# Rezoning Transportation Analysis

Petition Number: 2021-096

**From: Brandon Brezeale, PE**

Date	Description
8-20-2021	First Review (DBS)
9-17-2021	Second Review (WB)

SHEET NUMBER  
**RZ-1**

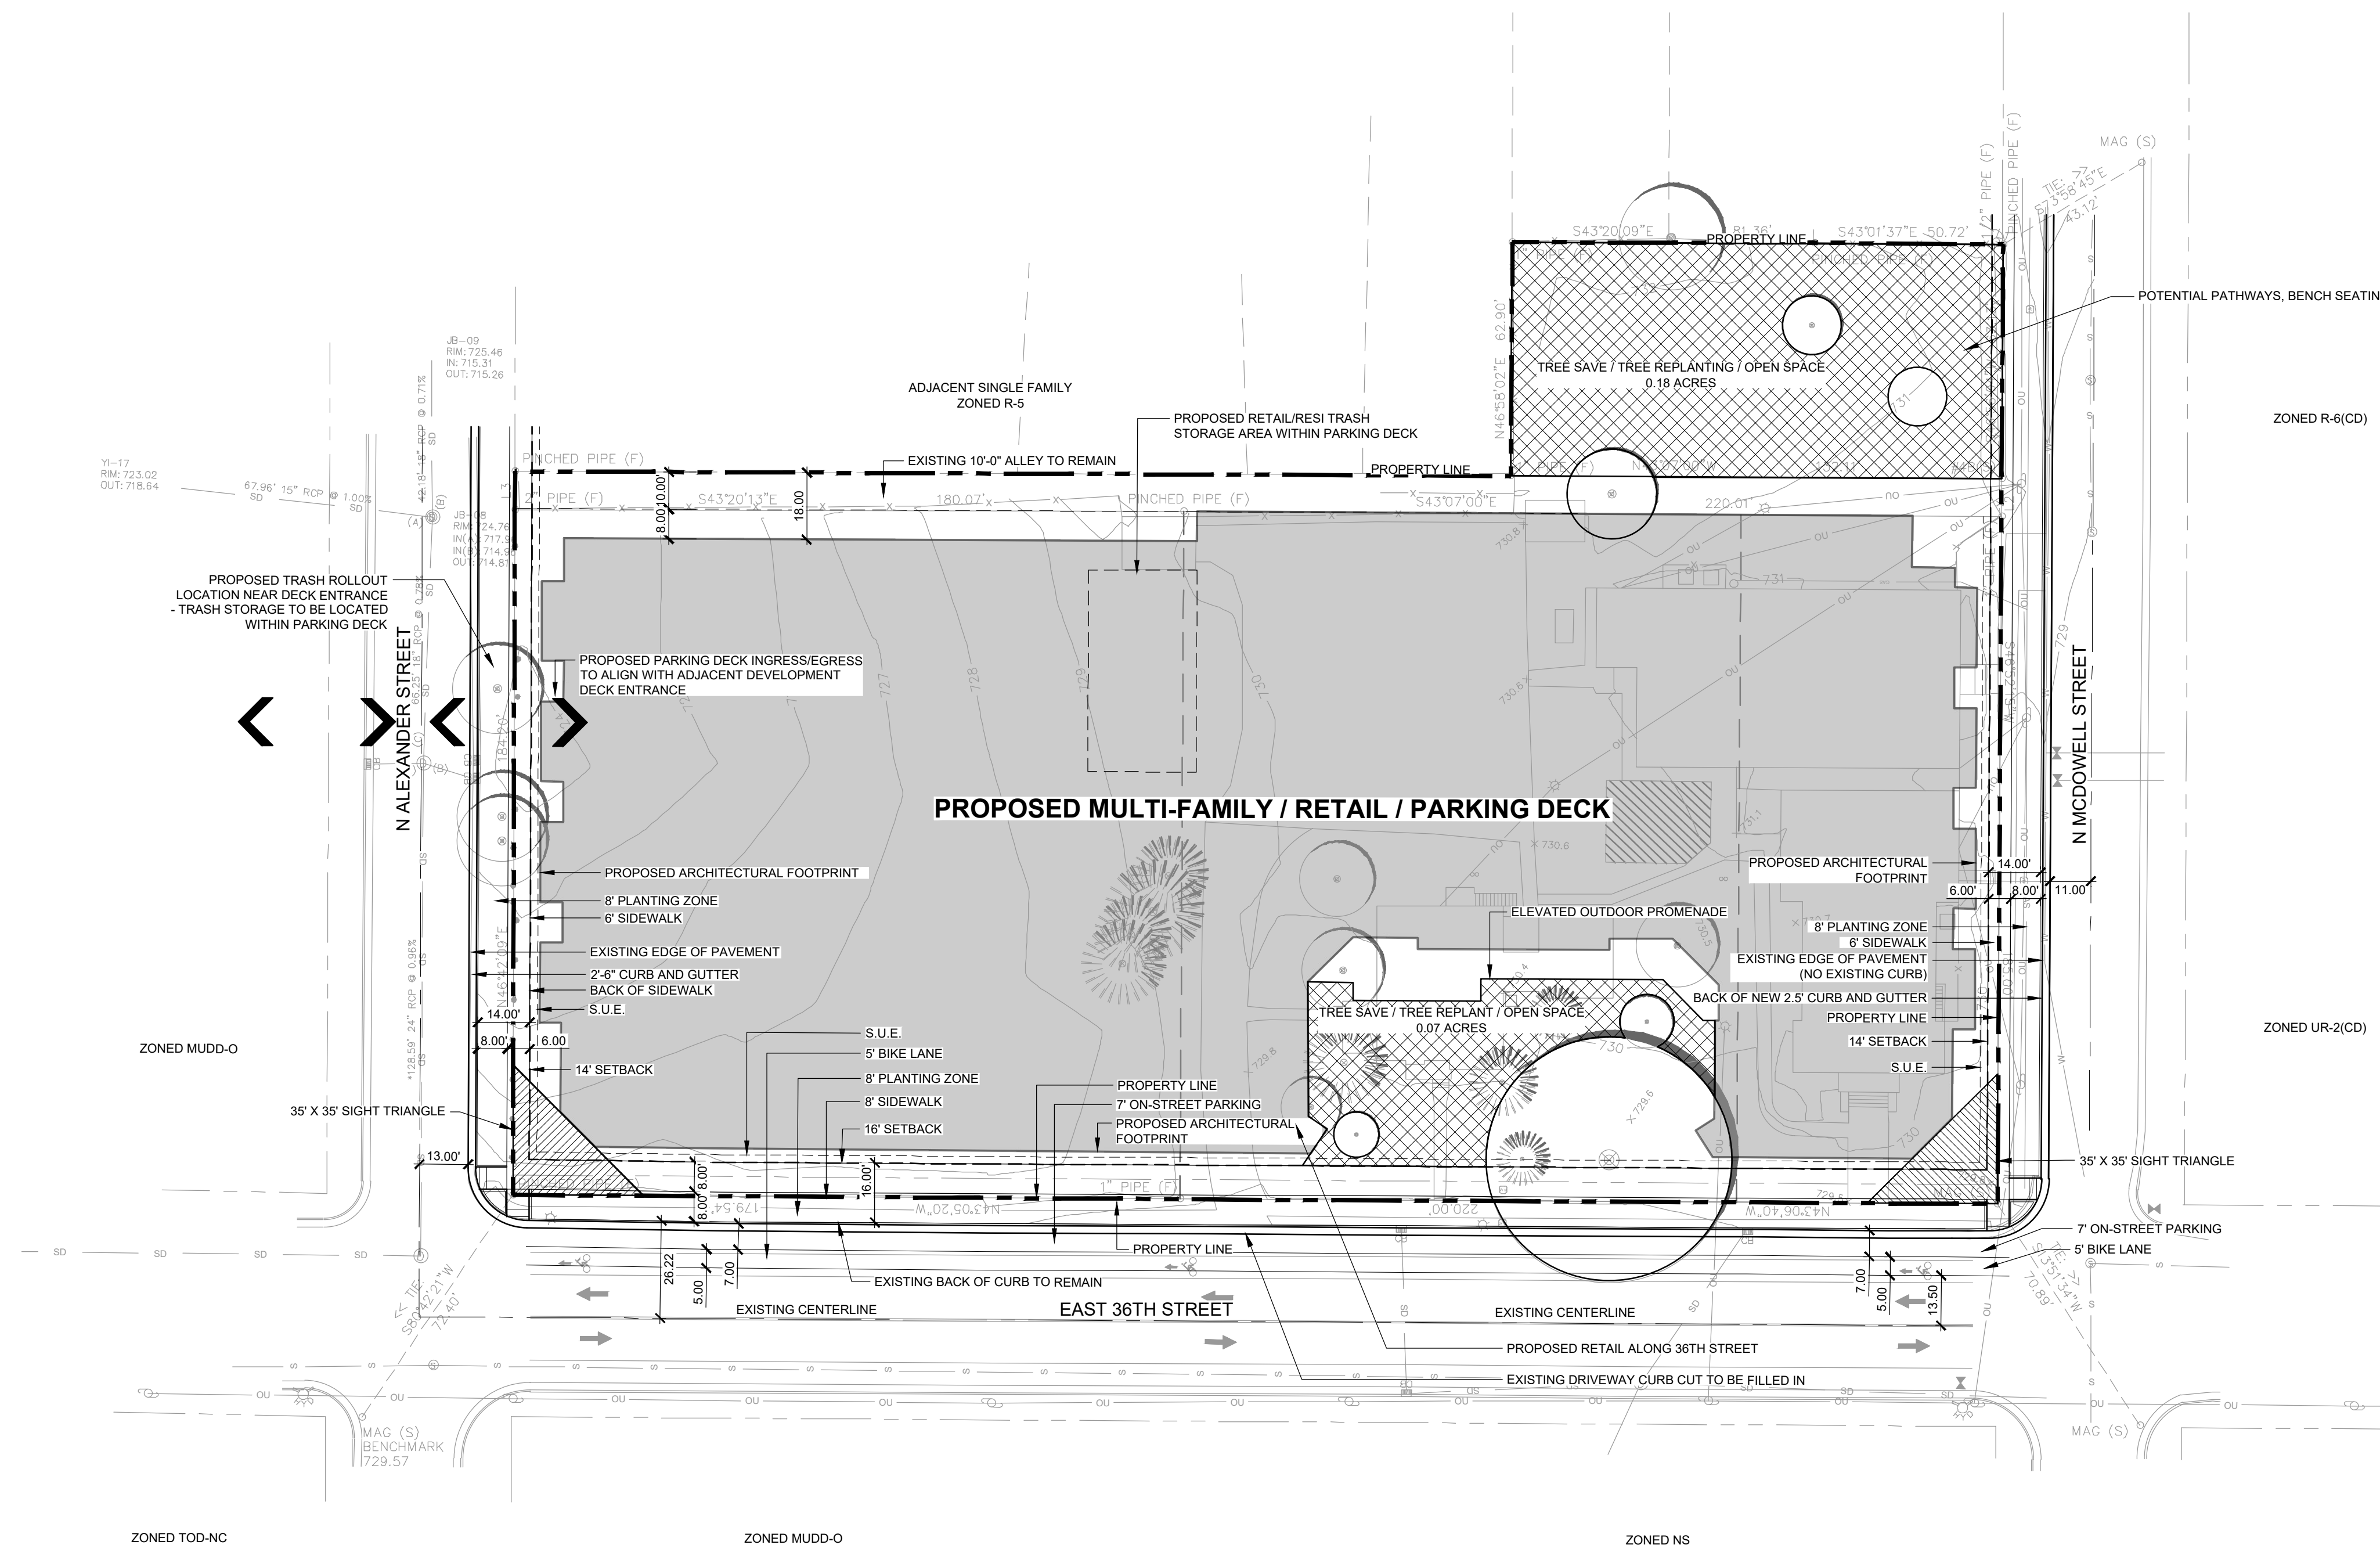
1. A Traffic Impact Study is necessary for the complete review of this petition due to the site generating more than 2,500 daily trips.

- 8. NEW COMMENT (09.17.2021)**  
Revise site plan to construct bulb-outs on East 36th Street at the corners of at North Alexander Street and North McDowell Street. Provide recessed on-street parking on North Alexander Street and North McDowell Street as SHOWN in the graphic below. New comment in response to request from Noda Neighborhood Board.
